WEST SUSSEX COUNTY COUNCIL CONSULTATION

TO:	Arun District Council FAO: Amber Willard
FROM:	WSSC – Highways Authority
DATE:	13 July 2026
LOCATION:	63 Annandale Avenue Bognor Regis PO21 2ET
SUBJECT:	BR/82/26/PL Demolition of the existing dwellinghouse and associated buildings, and the construction of a three-storey building comprising 9 No self-contained flats with associated landscaping, refuse storage, bicycle storage and parking spaces. This application is in CIL Zone 4 (Zero Rated) as other development.
DATE OF SITE VISIT:	n/a
RECOMMENDATION:	No Objection

| DRAWING NUMBER<br>ANN_PL_002              |                  |

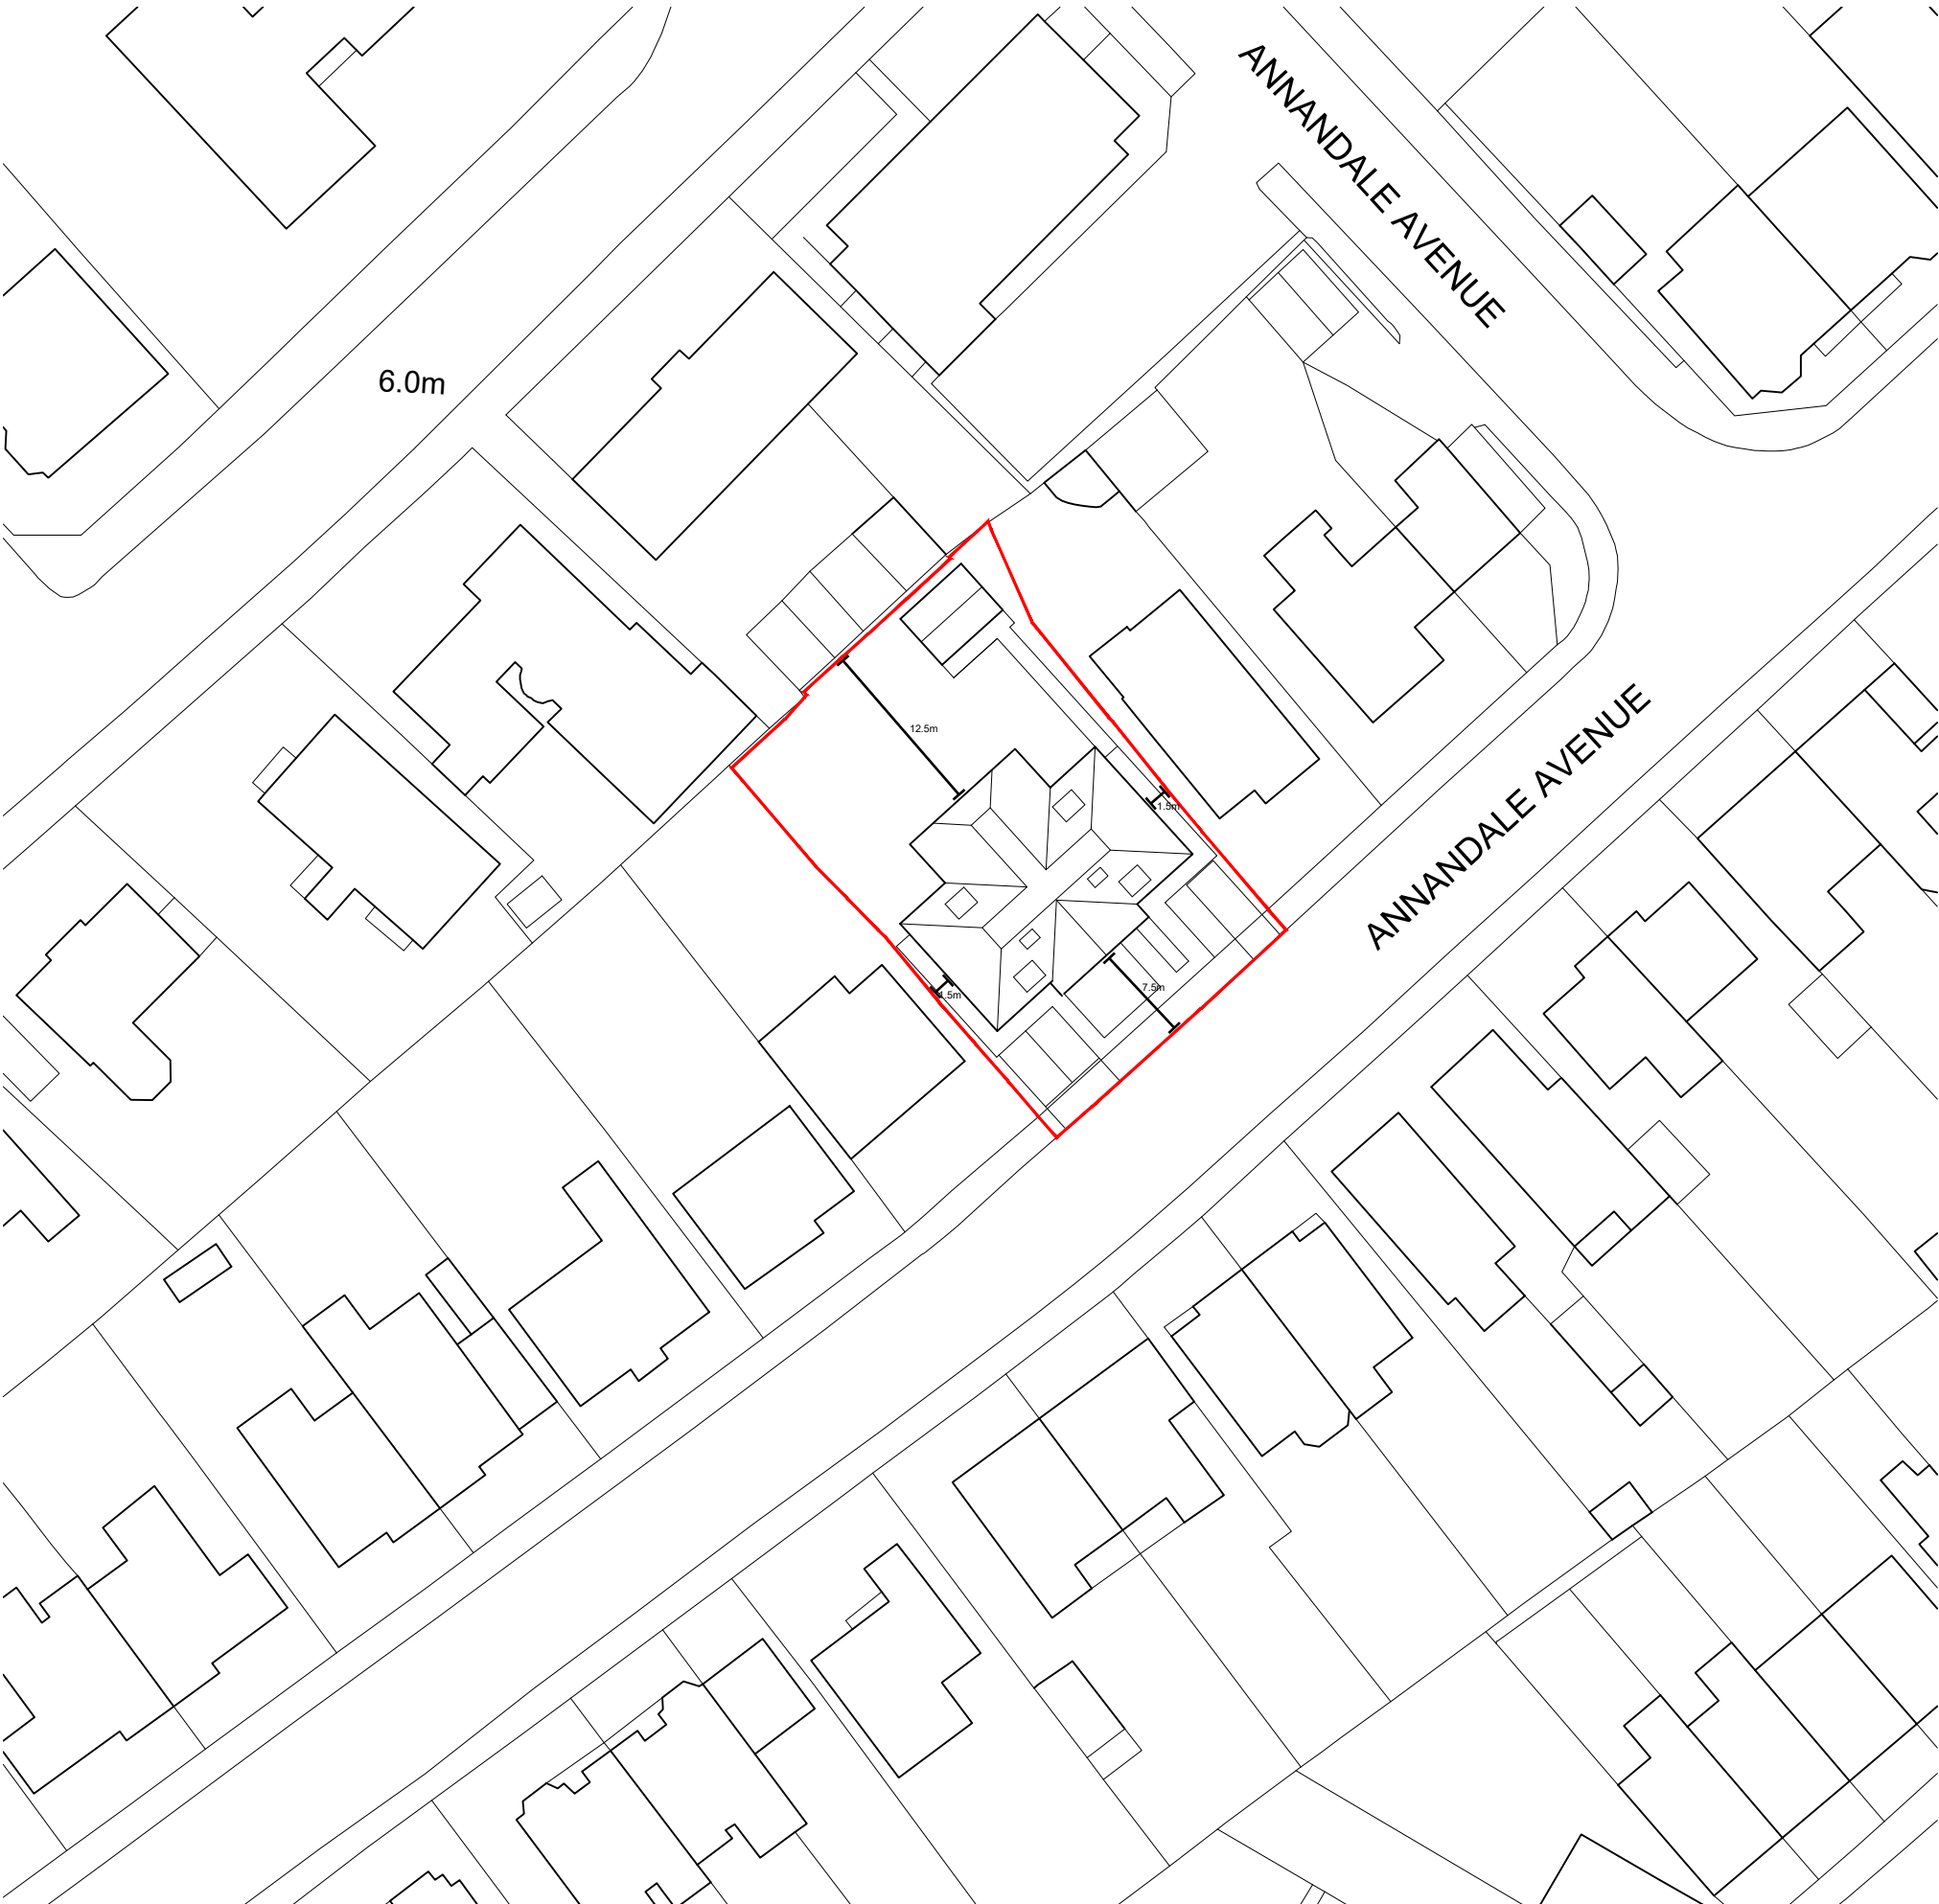
The development will offer 3 nos. vehicle parking spaces to the front of the development. The provision falls below the requirement set out within Arun Parking Standards. Therefore, a parking stress survey was commissioned to understand the vehicle occupancy levels along the neighbouring streets. The survey reveals parking occupancy of 80% within the 200 metres radius. Therefore, there is 20% provision for parking along neighbouring road should the residents wish to park.

No part of the development shall be first occupied until the vehicle parking spaces have been constructed in accordance with plans and details submitted to and approved by the LPA.

DRAWING NUMBER
ANN_PL_003

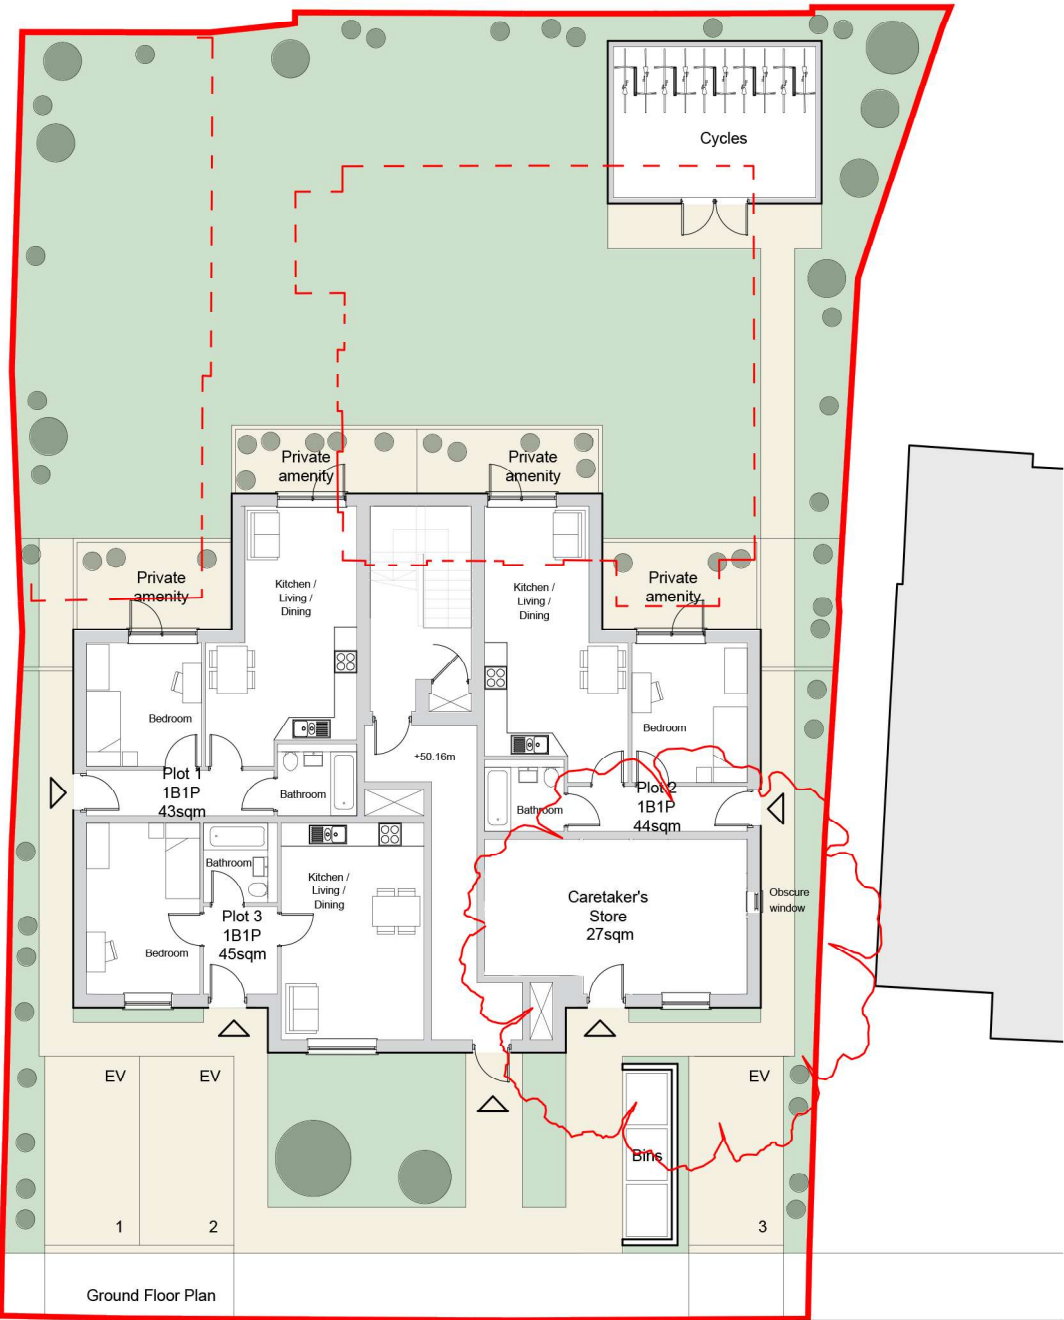
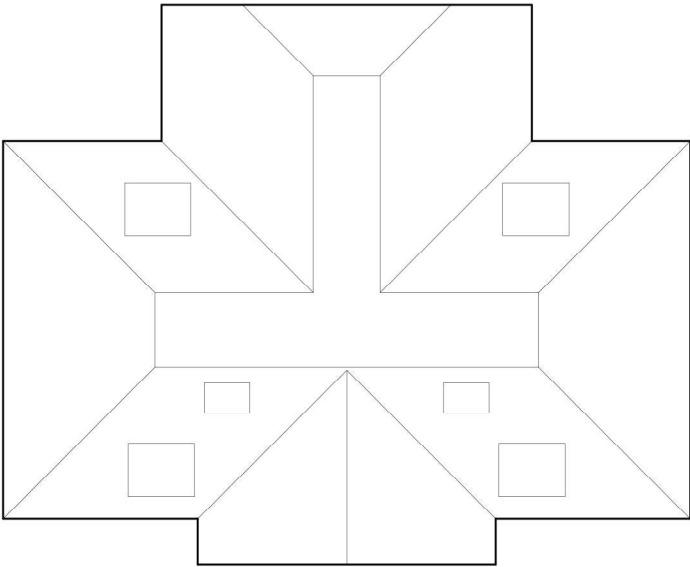
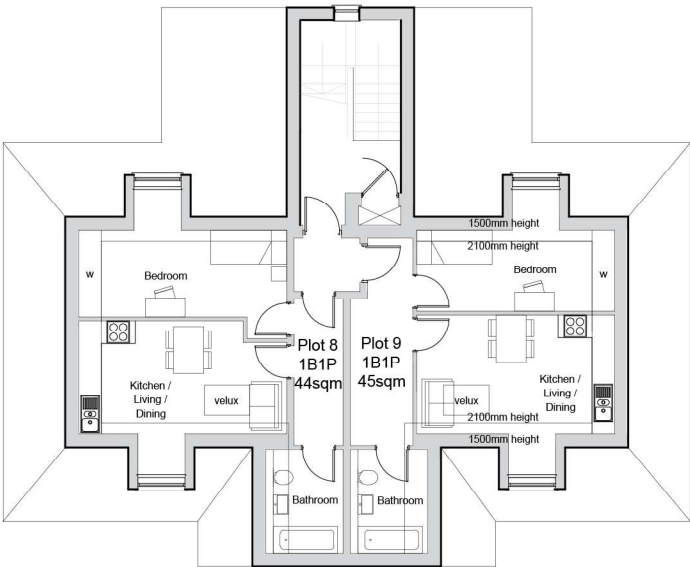
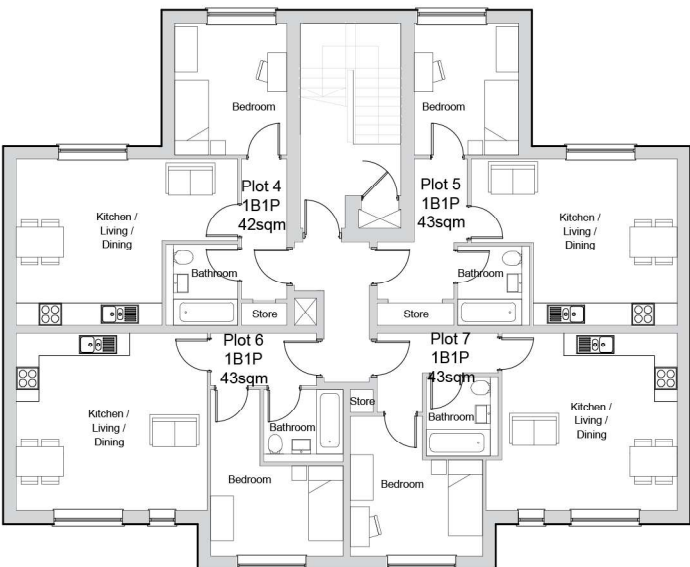
Cycle parking provision for 10 bicycles is made within a bike store to the rear of the building accessed via a side access. The Highway Authority advise provision of safe and secure bike storage facility in a well-lit and conveniently accessible location.

No part of the development shall be first occupied until covered and secure cycle parking spaces have been provided in accordance with plans and details submitted to and approved by the LPA.
